Your Ref: OWPC25356
Our Ref: BN/99/19/HH 15-10-2019
Please ask for:
Amber Willard

Erection of a trellis (existing), 1 x vehicular gate (existing), 1 x pedestrian gate (existing), 2 x vegetal pergolas and vehicular gates at both entrances to property. This application may affect the setting of a listed building. This application affects the character and appearance of the Church Lane Conservation Area.

Barnham Court Church Lane Barnham

Thank you for your internet representation made on 27th December 2019 which has been recorded as '**an objection**' with the comments as follows:

PROJECT:
Barnham Court, Church Lane, Barnham
Elevation of Front Entrance with proposed Gates

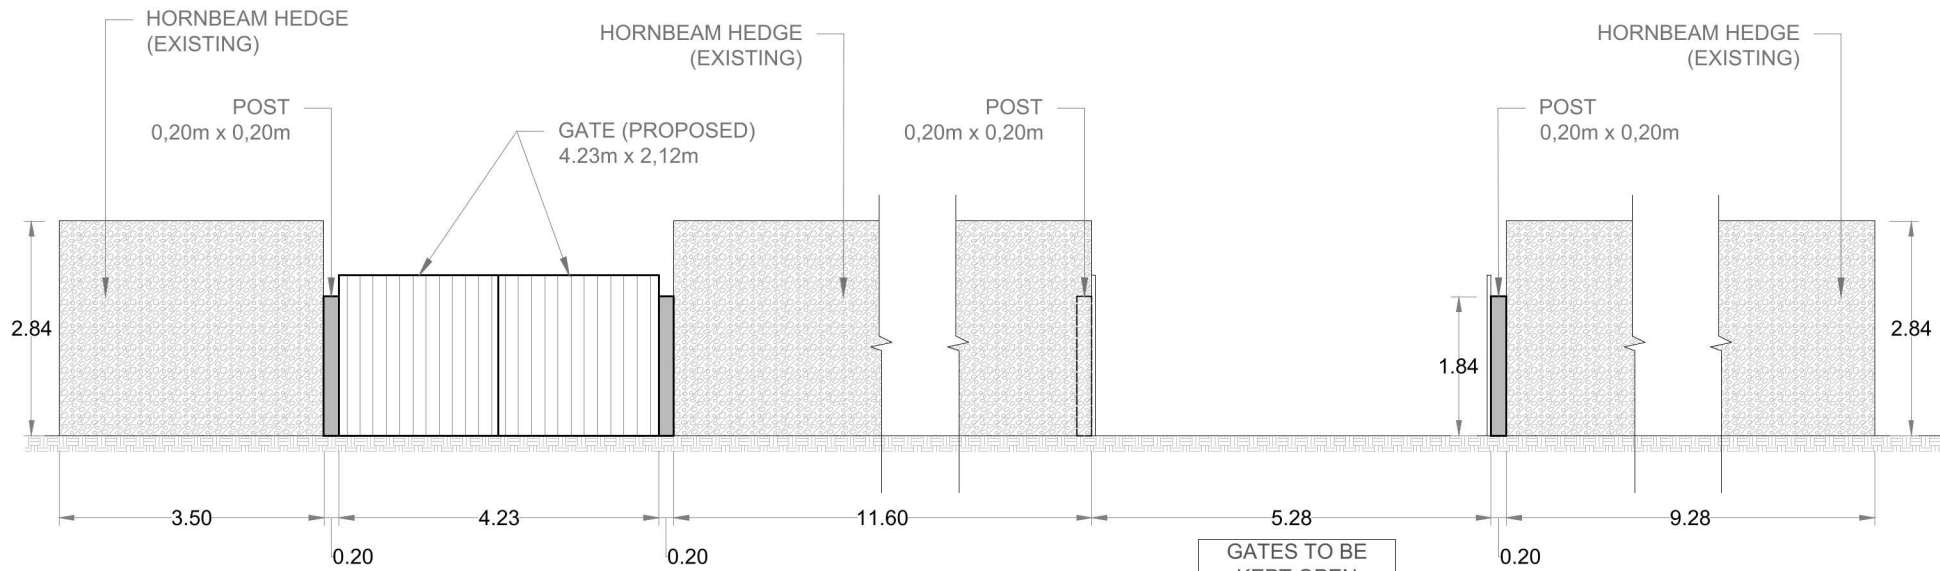
Since the Conservation Area was designated the open field and openness noted has been obscured by the pleach hedging, obscuring the hitherto open views of Barnham Court which is now more or less invisible from Church Lane. The construction of gates at the entrance of the drive will further obscure the views of Barnham Court and "...the sweep of the access lane approach" noted by Foyle.

2.If the proposed gates at the right hand entrance is to be kept open, what is the point of them? If they are to be permitted, it should be made a condition of the consent that they be left open at all times.

3.How will the proposed gates prevent trespass to the drive when one spur is already shut off by a chain, and the gates to the right hand entrance are to be left open?

4. We have rights of access (including vehicular access) over both limbs of the drive which will be interfered with if the proposed gates are permitted, particularly if they are shut. If they are to be permitted, it should be a condition of consent that the gates be left open at all times.
